Application for Plan Review

Application # FMFW1812-0005

Name of Project: PJ's Truck Bodies

Pyro Chem U.L. 1254 AUTO SPRAY PAINT BOOTH FIRE SUPPRESSION SYSTEM

Recirculation Plenum  
No Exhaust Duct

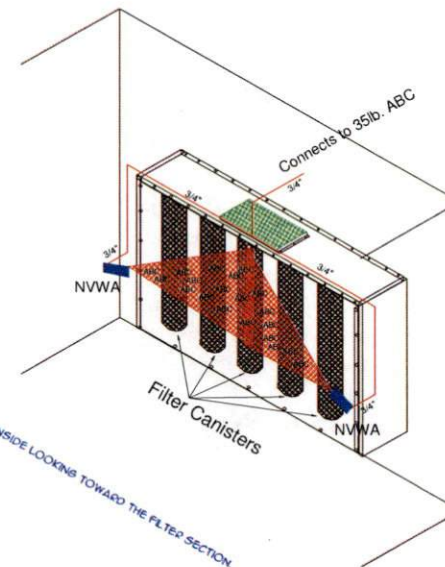
EXHAUST FAN & INCOMING AIR MUST SHUT DOWN ON DISCHARGE OF THE FIRE SUPPRESSION SYSTEM.
THE BUILDING FIRE ALARM MUST BE CONNECTED IF BUILDING IS EQUIPPED WITH A FIRE ALARM SYSTEM.
HEATED BOOTHS GAS SUPPLY MUST SHUT DOWN ON DISCHARGE OF THE FIRE SYSTEM.
